From: Simon Davis
Sent: 07 April 2022 12:43
To: Lisa Jackson [REDACTED]
[REDACTED]

Subject: RE: Y/3/22/OUT Y/3/22/OUT -Land West of Bilsham Road, Yapton

Client	LANDLINK ESTATES
Project	LAND WEST OF BILSHAM ROAD, YAPTON
Title	MAISONNETTES - BINS & CYCLE STORE

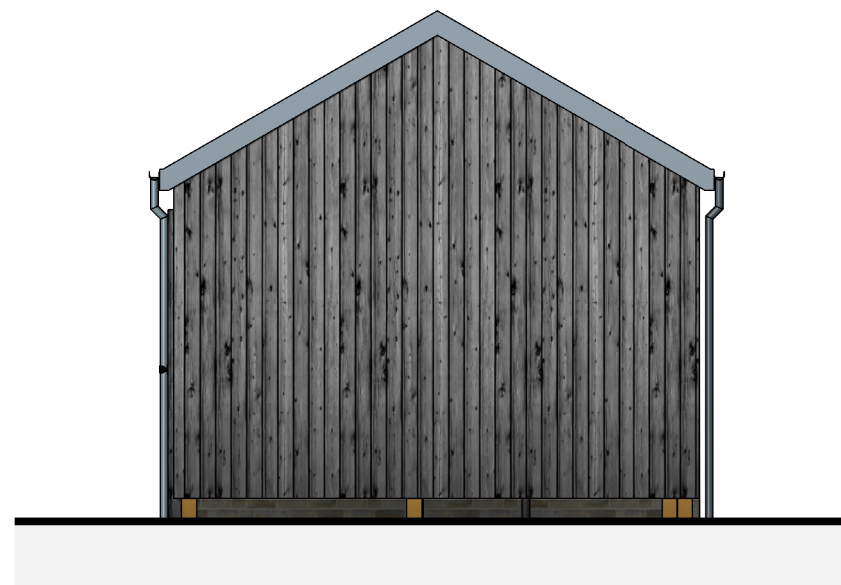
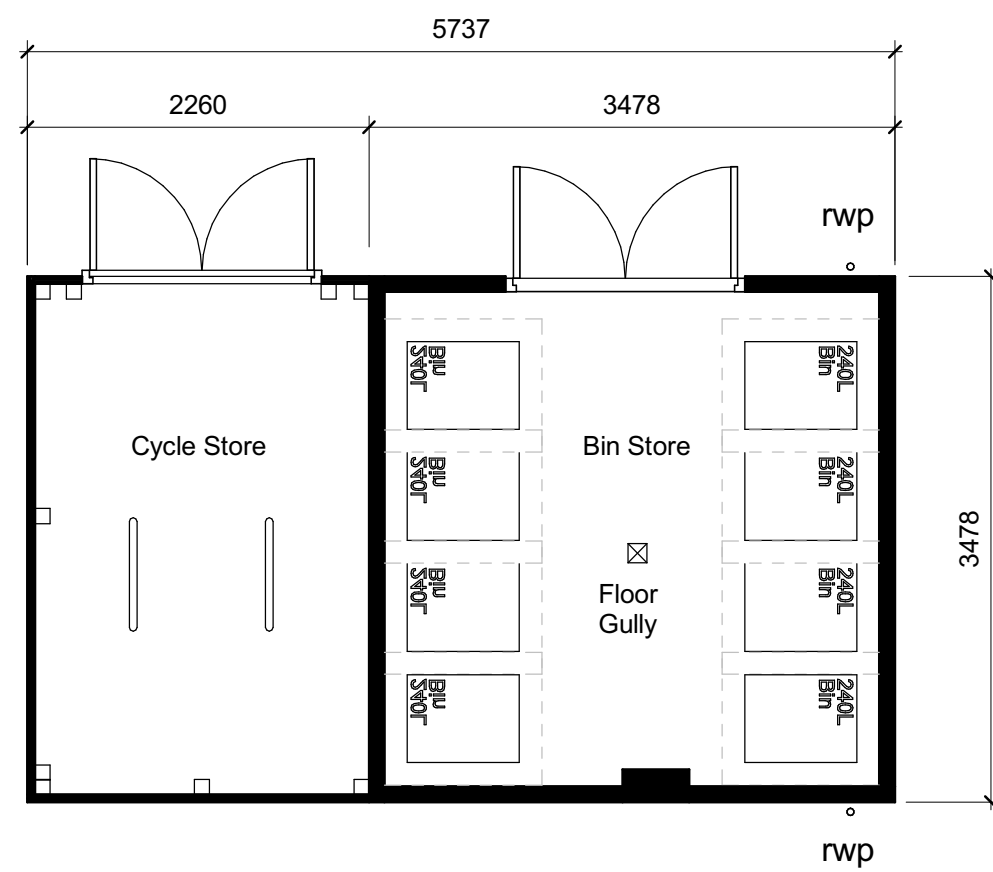
- There does not appear to be any private space for the two GF flats in the 10-13 apartment building. Is the intention that their amenity is served by the communal space around the building? I acknowledge the balconies for the two FF flats.
- I assume your client will agree to a condition to secure provision of M4(2) homes as per the YNDP policy? I couldn't see any reference to this except a tick in the D&A to say it has been considered.
- Our Parking Standards SPD also refers to the need to ensure 5% disabled parking provision as per Manual for Streets. I can't see any reference to disabled parking in the submission and this needs to be shown.
- I can see an Appendix A Tree Schedule and an Arb Impact Plan but no accompanying Tree Report. I have checked the submitted portal files and there wasn't one there either. Is there supposed to be an accompanying report?

1. Can I suggest for the Units 10-13 the following condition is imposed. " Notwithstanding the details shown on plan 964-MP-02B Rev B a fence will be erected between plots 10 and 11 to create private outdoor space for each unit."
2. I am not sure what M4(2) housing is, or what policy reference you are making to YNDP? I am assuming this is internal space standards? I am not sure a condition is required for phase 1 as they meet the standard and the other phases will be secured by reserved matters applications?
